October 22, 2021  
County File: OAR-21-101

Re: Countryside South ODP Amendment No. 1

To: City of Fountain Planning Supervisor Kristy Martinez (Kristy@fountaincolorado.org)

CAD FILE: 21003308-EX-SUB-BASIN-ANALYSIS.DWG

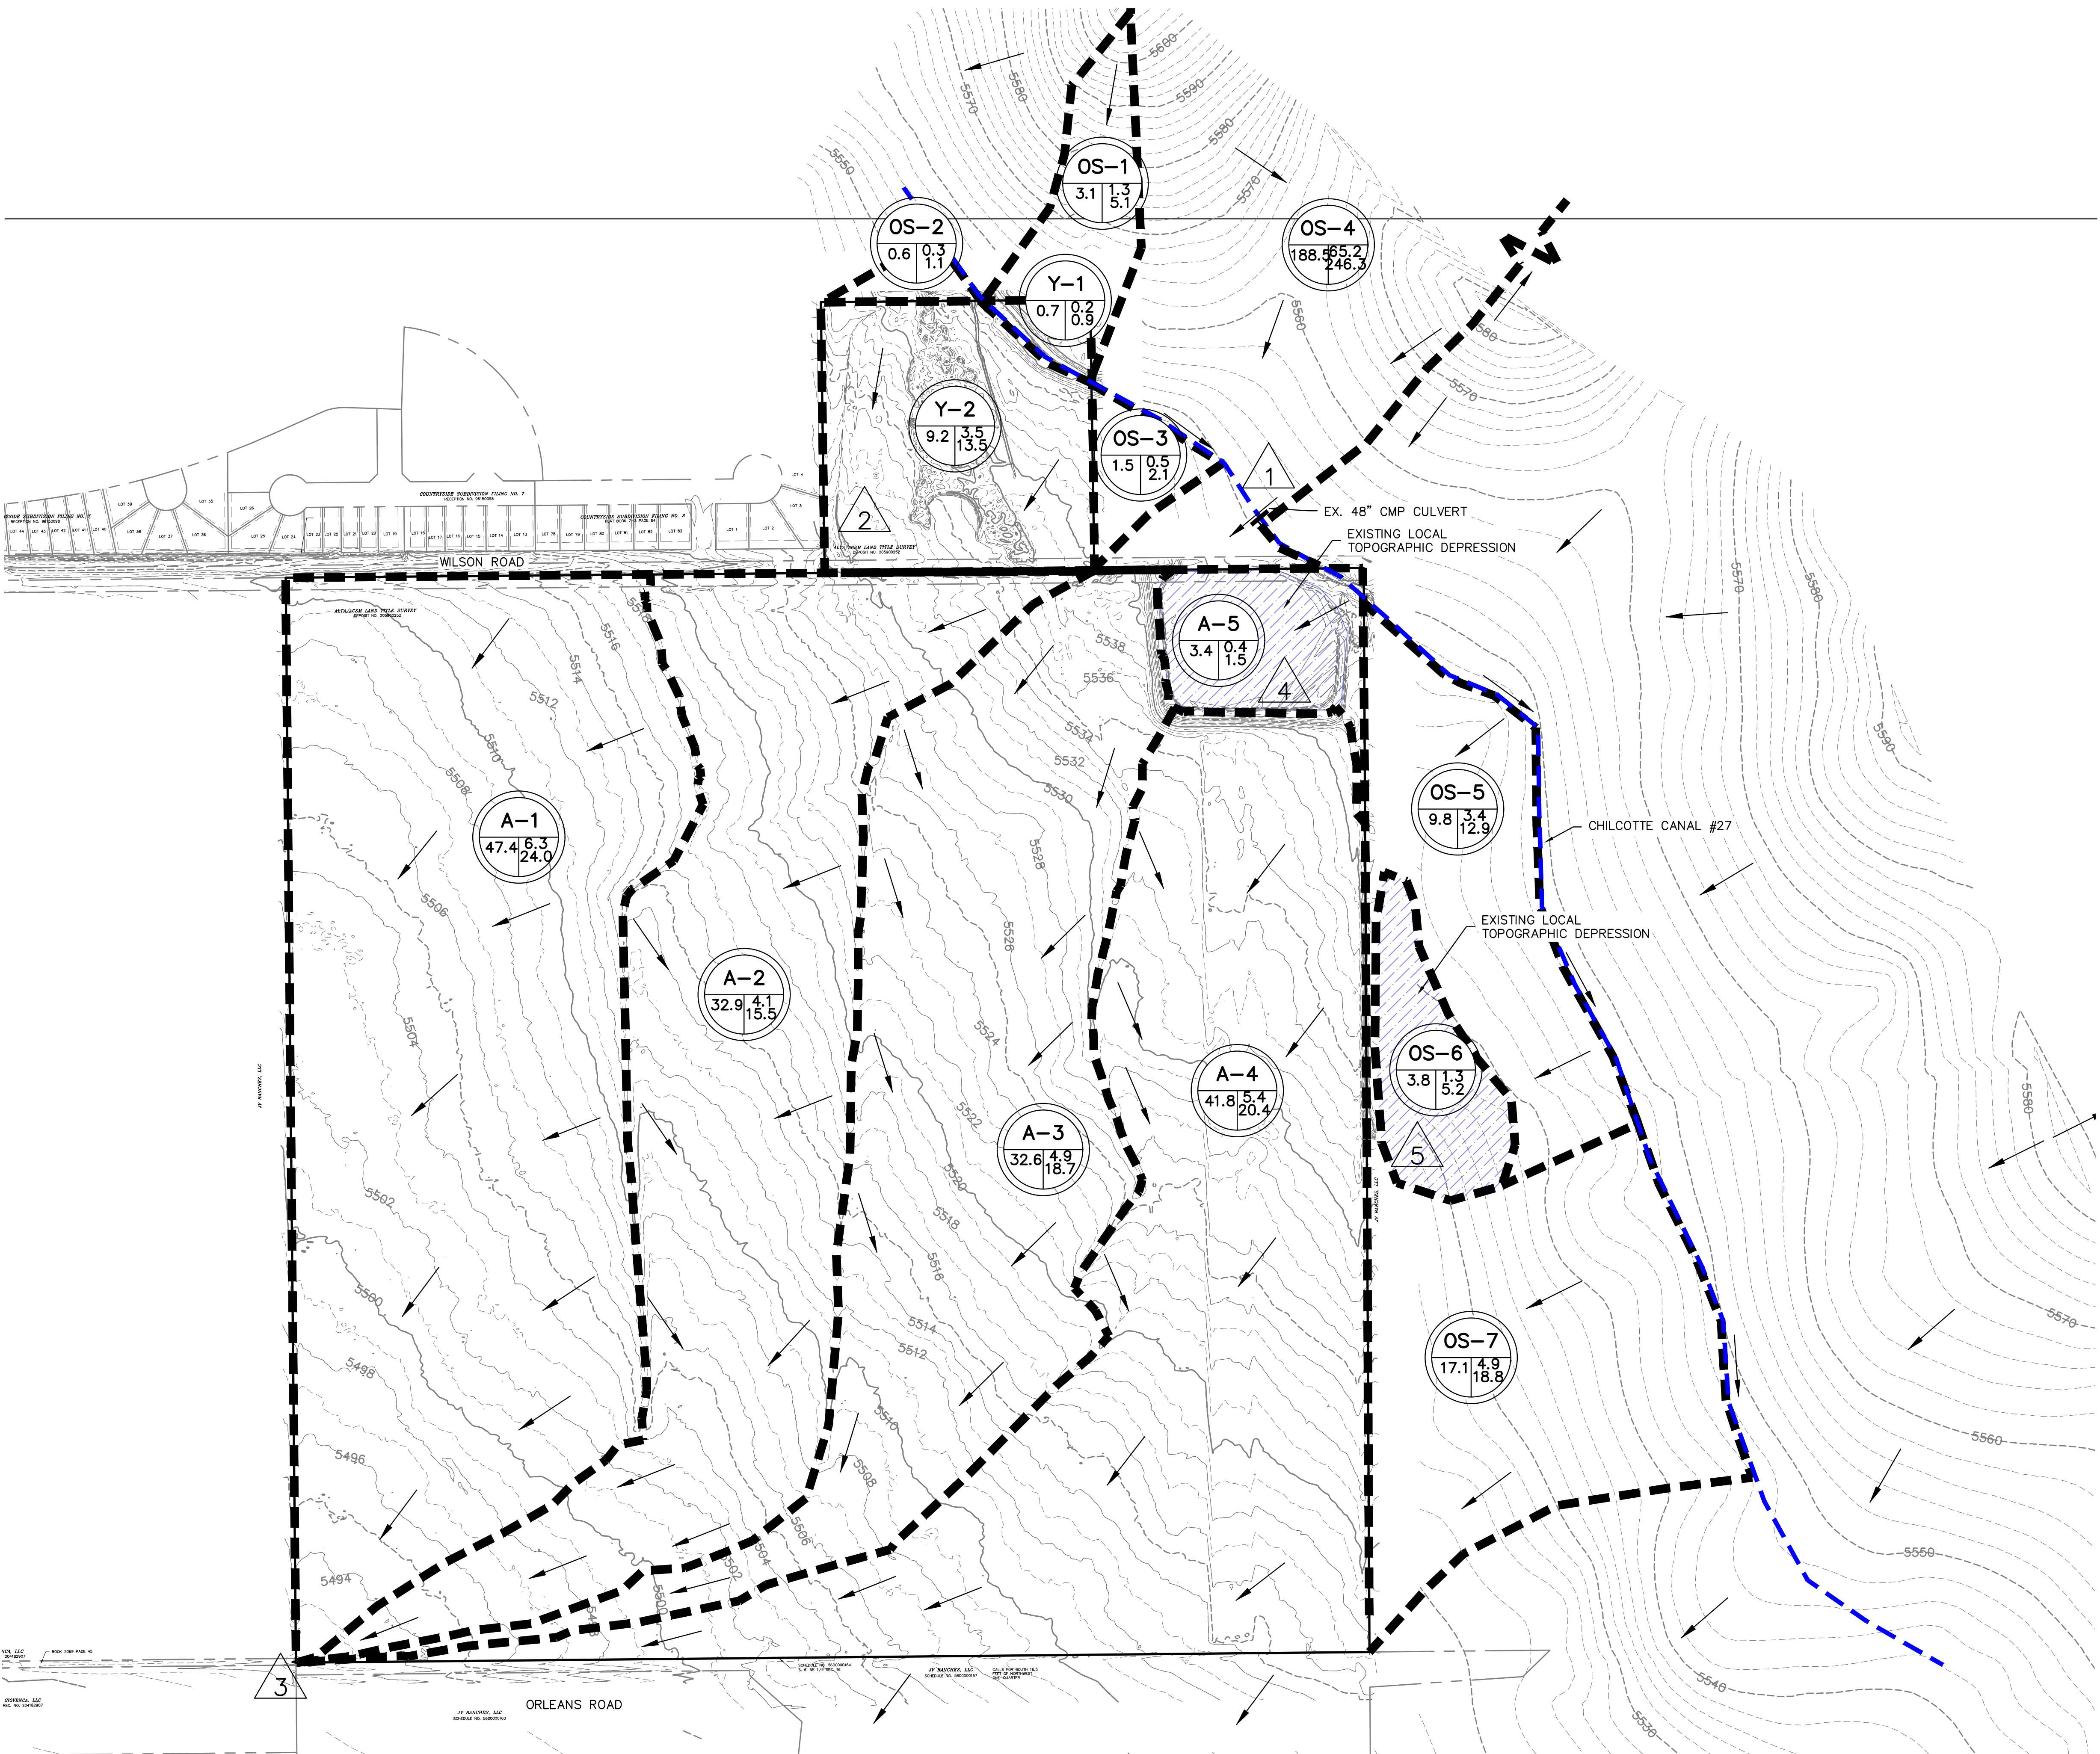
2. Elaborate on the offsite flowpath from design point 3. Where does it go after the roadside ditch? Analysis needs to be taken down to the suitable outfall location. Suitable outfall refers to an existing natural stream/channel that is hydraulically adequate, or existing man-made system that is hydrologically and hydraulically adequate. Offsite improvements may be required to the conveyance system between the pond outfall and the receiving suitable outfall.
